RE: Transmittal of Comments – Boat Ramp Short Plat (SP-14-00004)

Subject: SP-14-00004 – Boat Ramp
I-90 MP 136.5 Left vicinity

RE: Boat Ramp Short Plat, SP-14-00004

CRUSE & ASSOCIATES
PROFESSIONAL LAND SURVEYORS
217 E. Fourth St. P.O. Box 959
Ellensburg, WA 98926 (509) 962-8242
BOAT RAMP SHORT PLAT

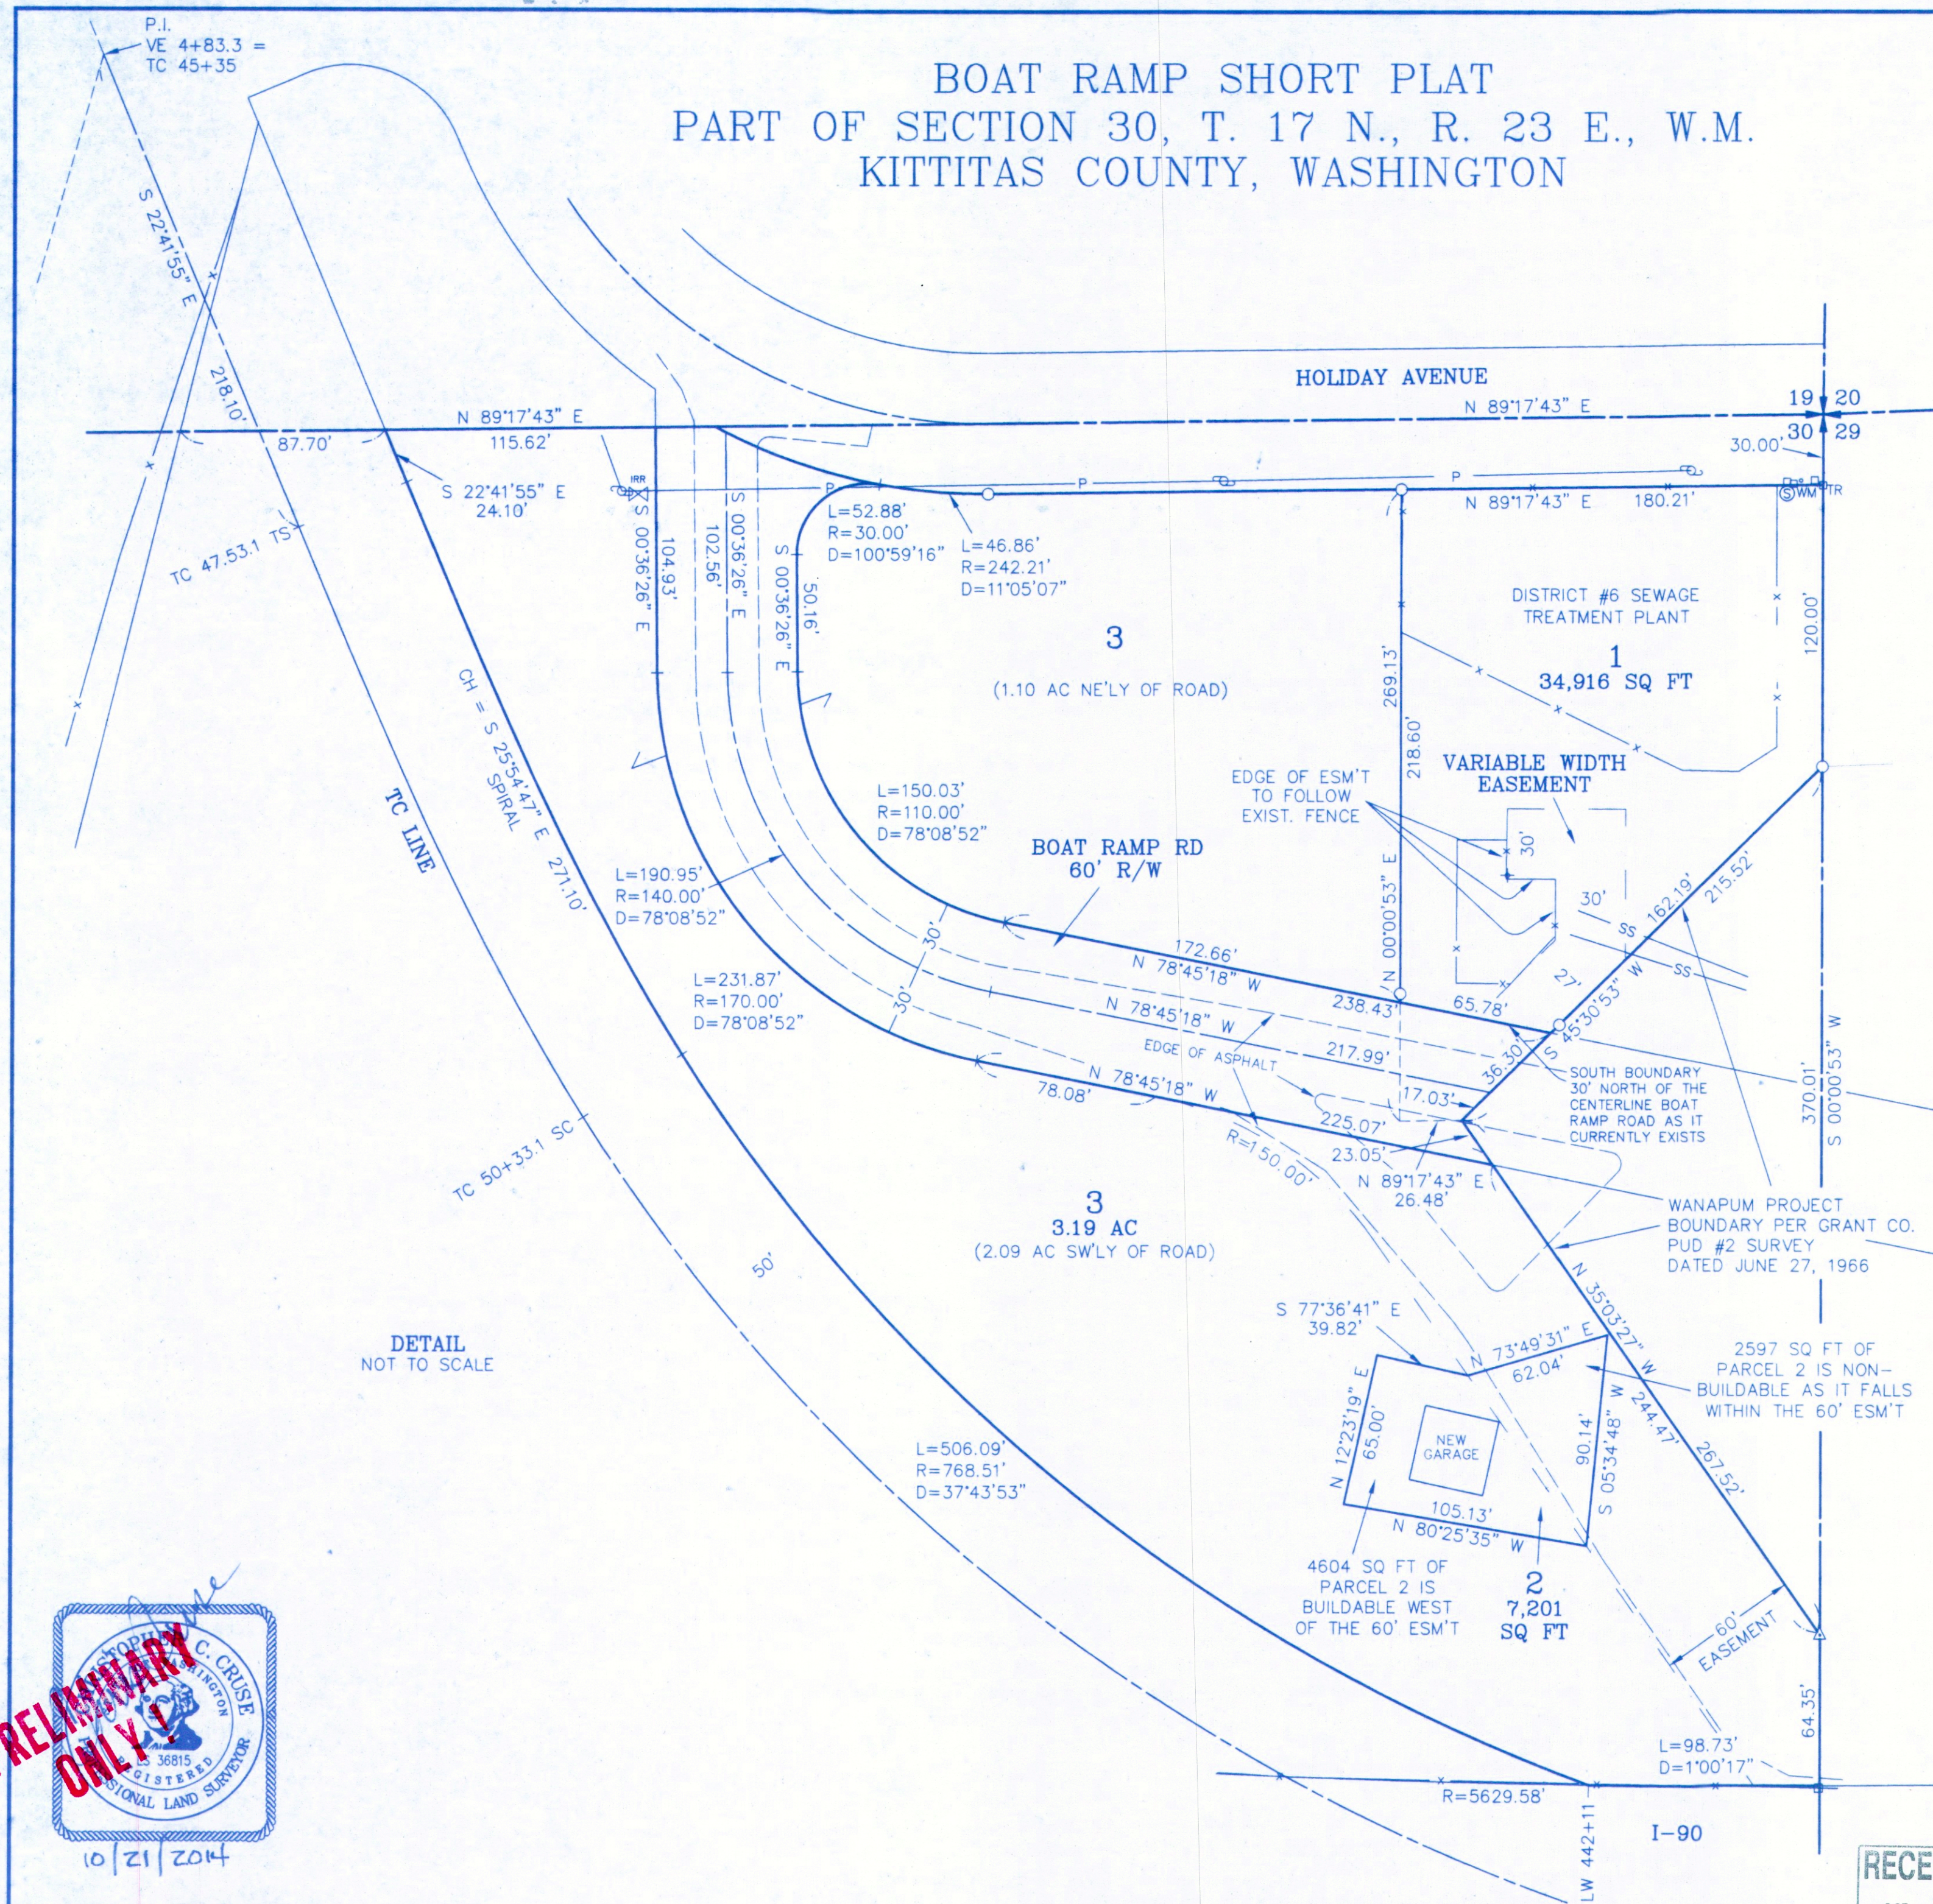
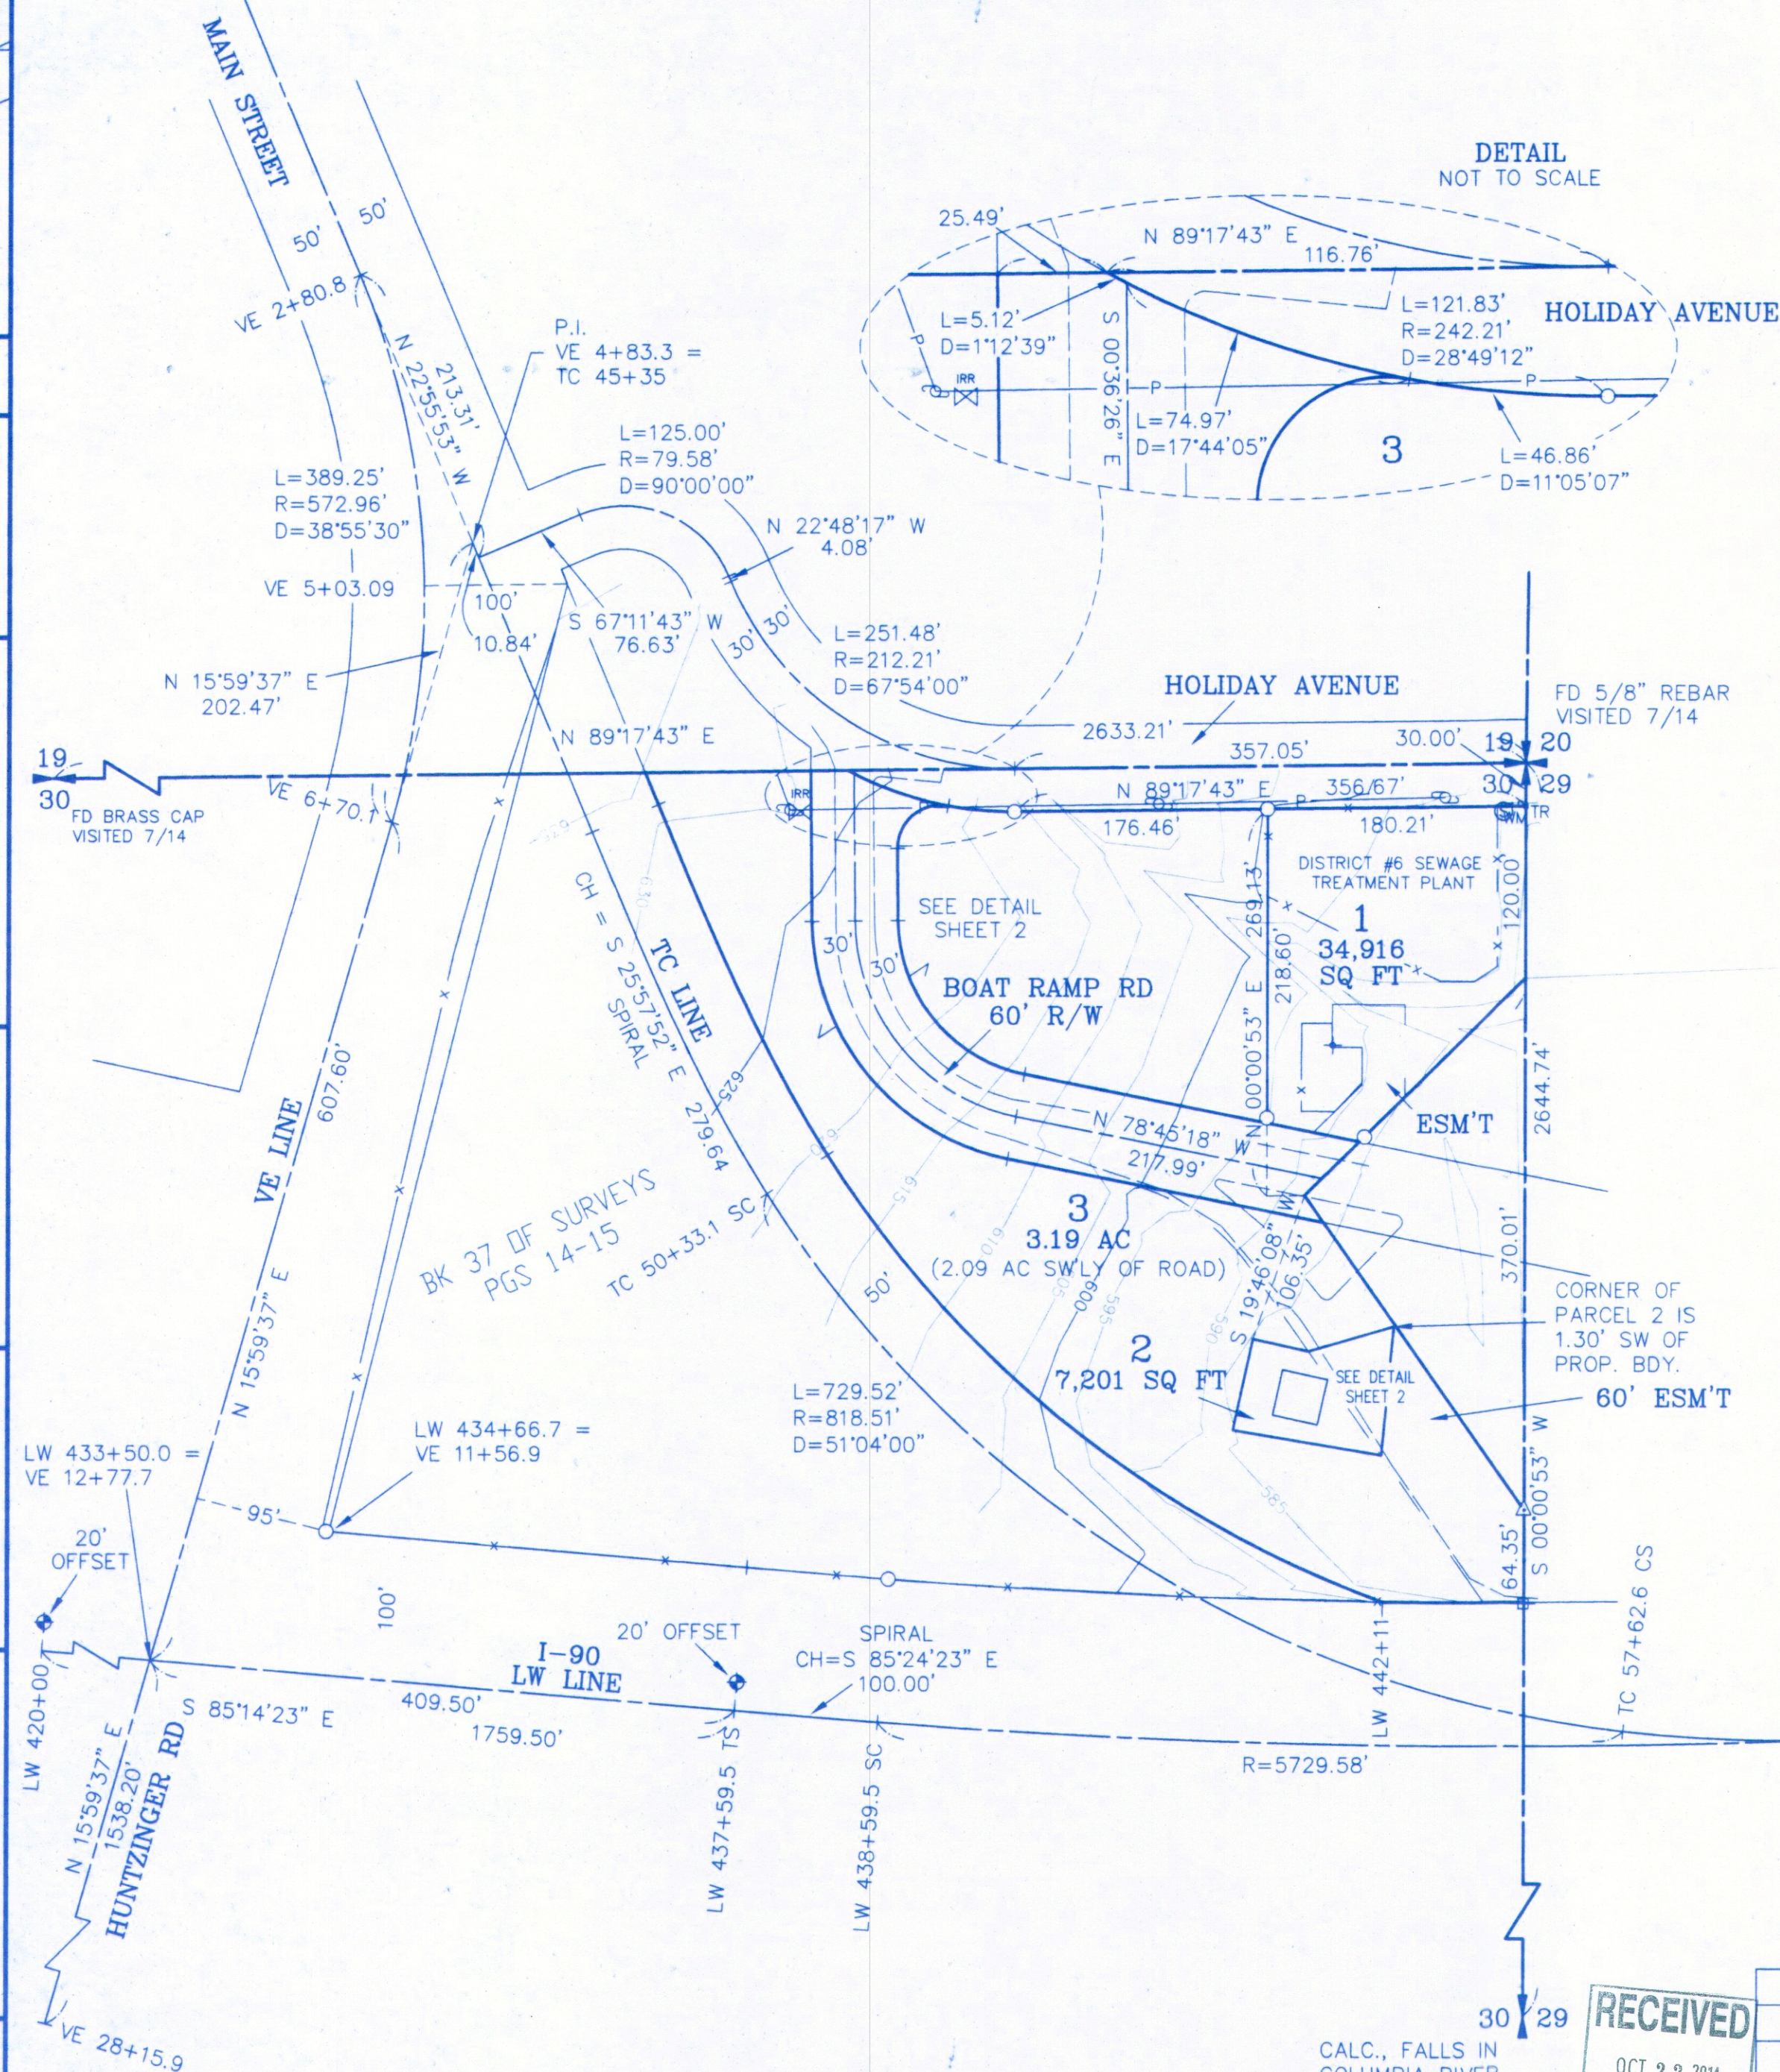
We have reviewed the proposed project. The revised survey of the Boat Ramp Short Plat represents correctly WSDOT property adjacent to Lot 3. We have the following comments.

- The proposed project is adjacent to Interstate 90 (I-90). I-90 is a fully-controlled limited access facility with a posted speed limit of 70 miles per hour. No direct access to I-90 will be allowed.
- Stormwater and surface runoff generated by this project must be retained and treated on site, in accordance with regulating agencies' standards, and not allowed to flow onto WSDOT right-of-way.
- Any proposed lighting should be directed down towards the site and away from I-90.
